**Consultation Response from KC,
Trees****2021/91975 Croft House Surgery, 1145, Manchester Road, Slaithwaite, Huddersfield, HD7 5JY****Redevelopment of Croft House Surgery with demolition of existing 2 storey flat roof car port / office building, alterations to existing building to form 5 residential units and erection of 3 dwellings. (within a Conservation Area)****Date Responded: 06/08/21 | Responding Officer: Nick Goddard | Responding Ref: CA23**

Proposed Site Plan 1:100

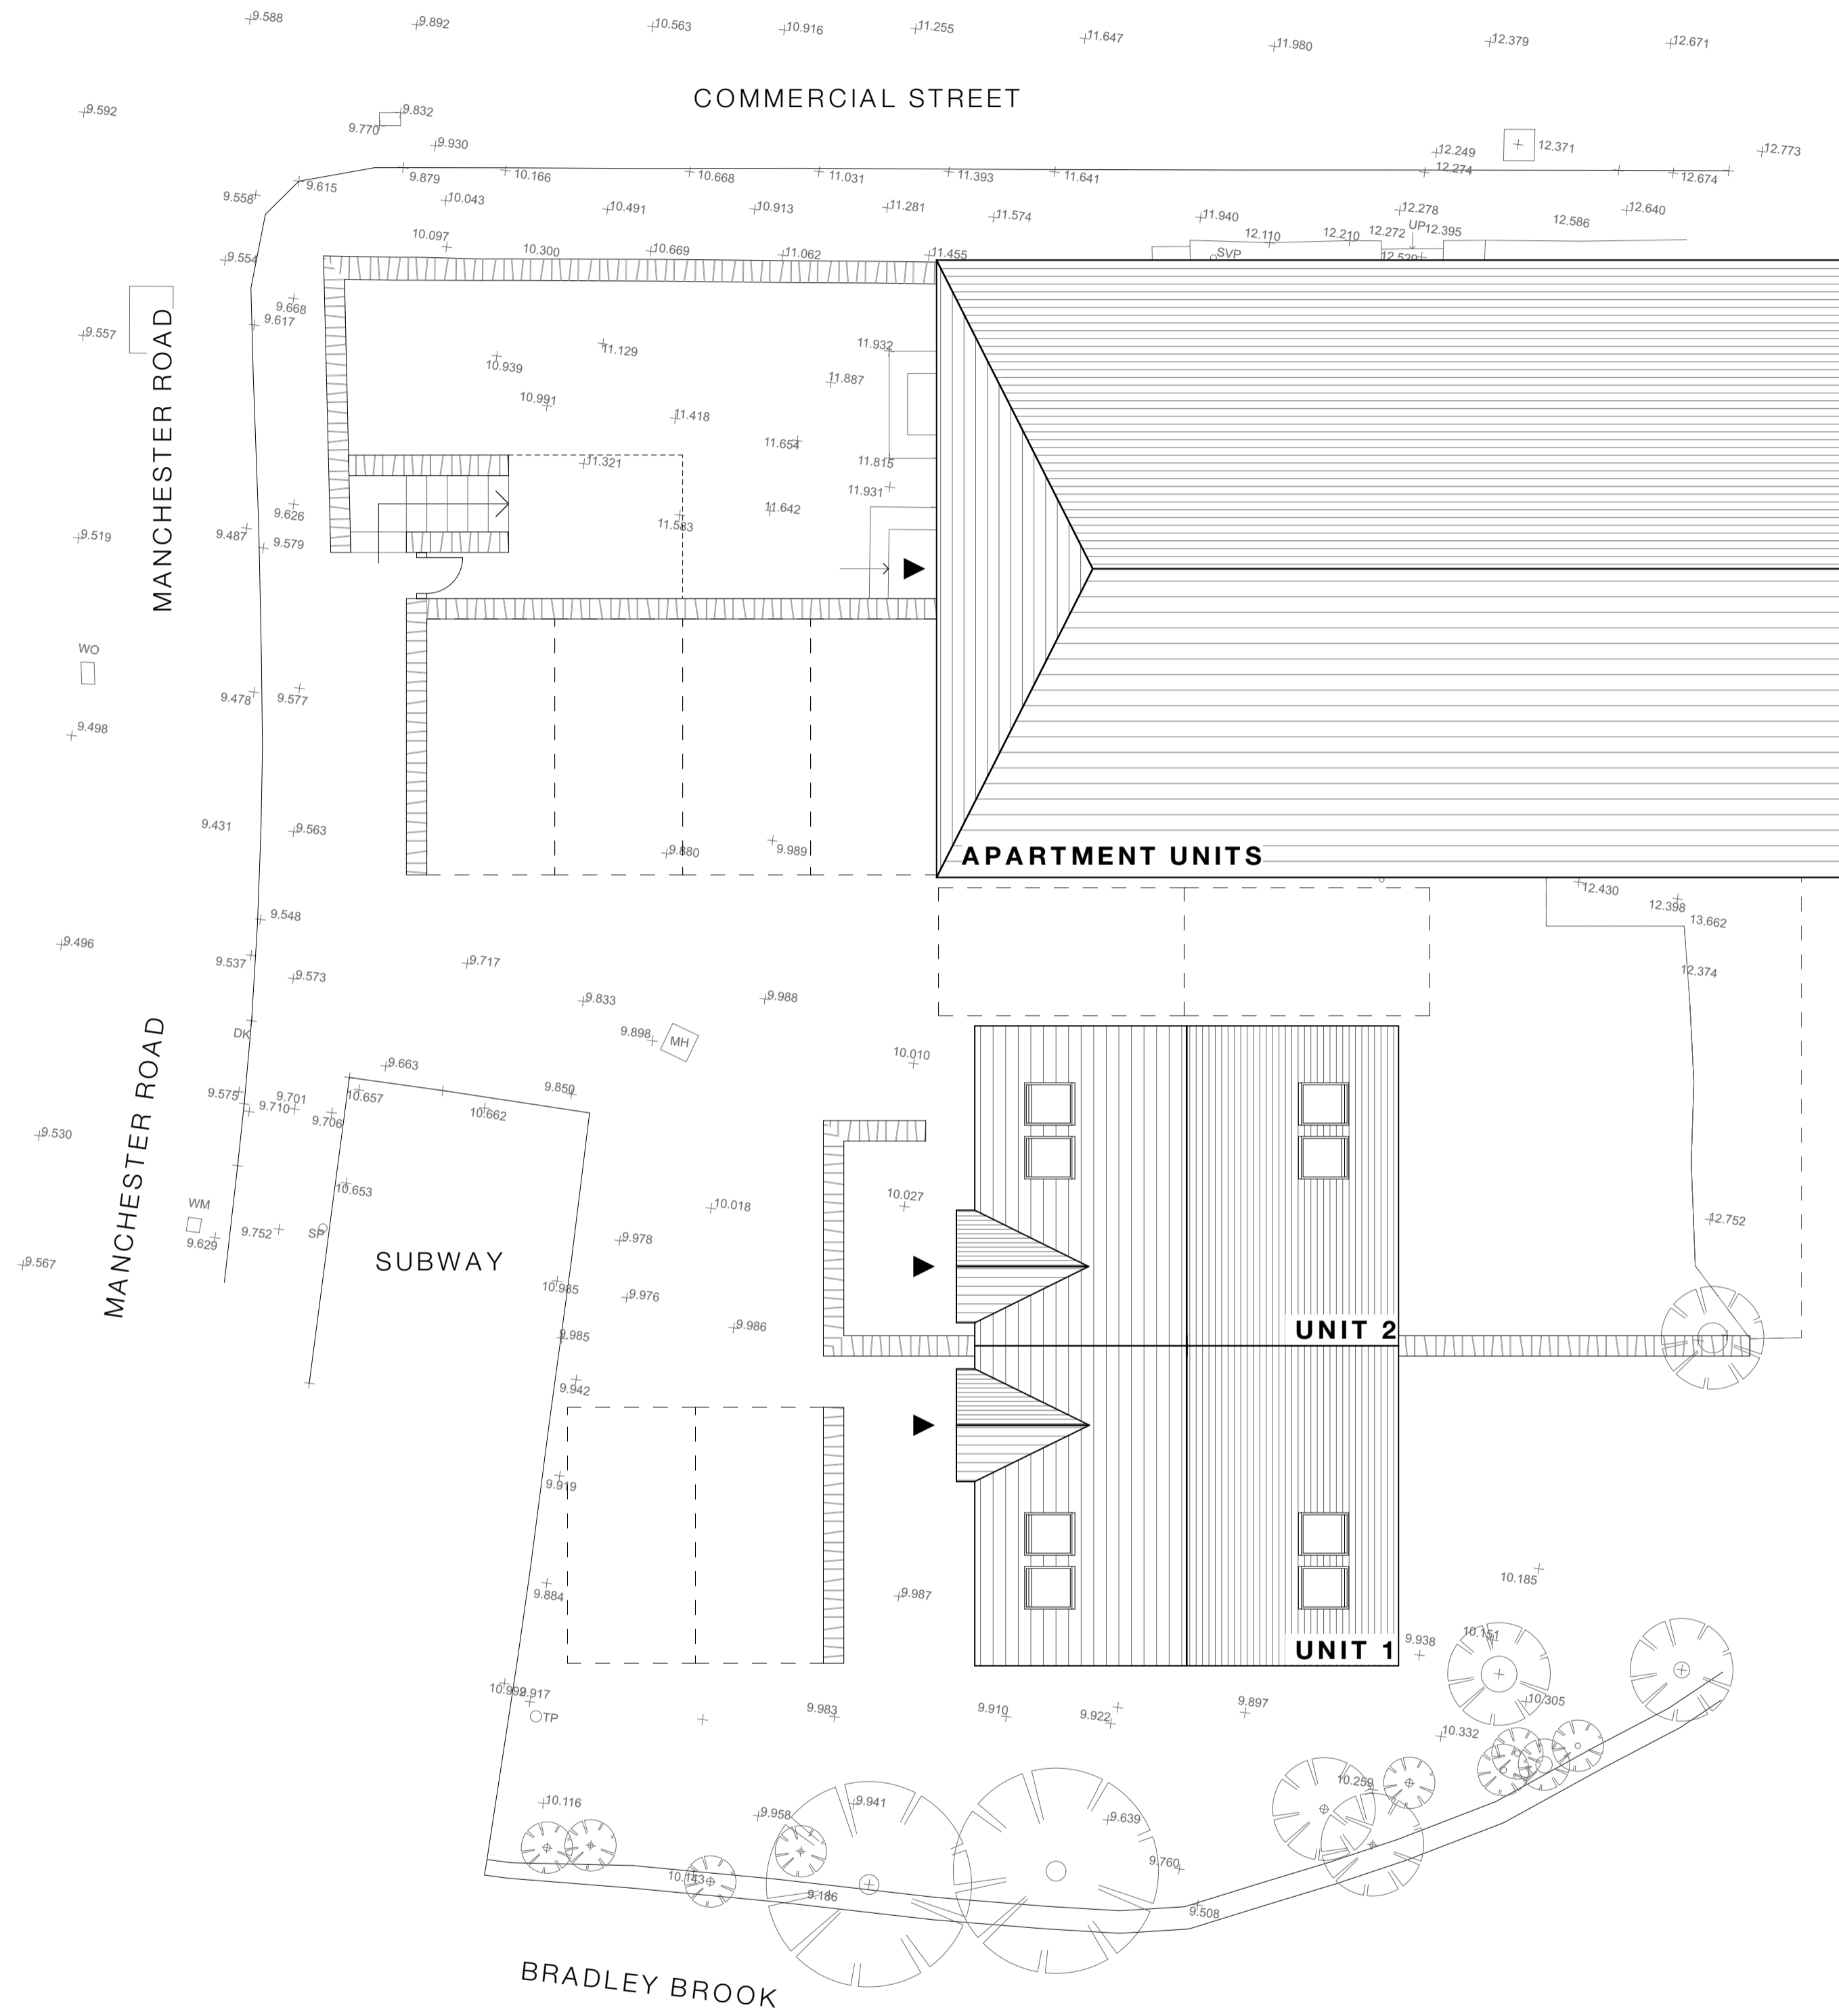
No tree information has been submitted, making it difficult to assess the proposals and their potential for impact on trees worthy of retention. At present it appears the proposals would require the removal of a large mature tree on the boundary with the stream or introduce new dwellings in close proximity to trees with only limited outdoor amenity space, all of which is likely to be shaded.

Without further information the proposals do not appear to meet policies LP24i and LP33 of the Kirklees Local Plan.
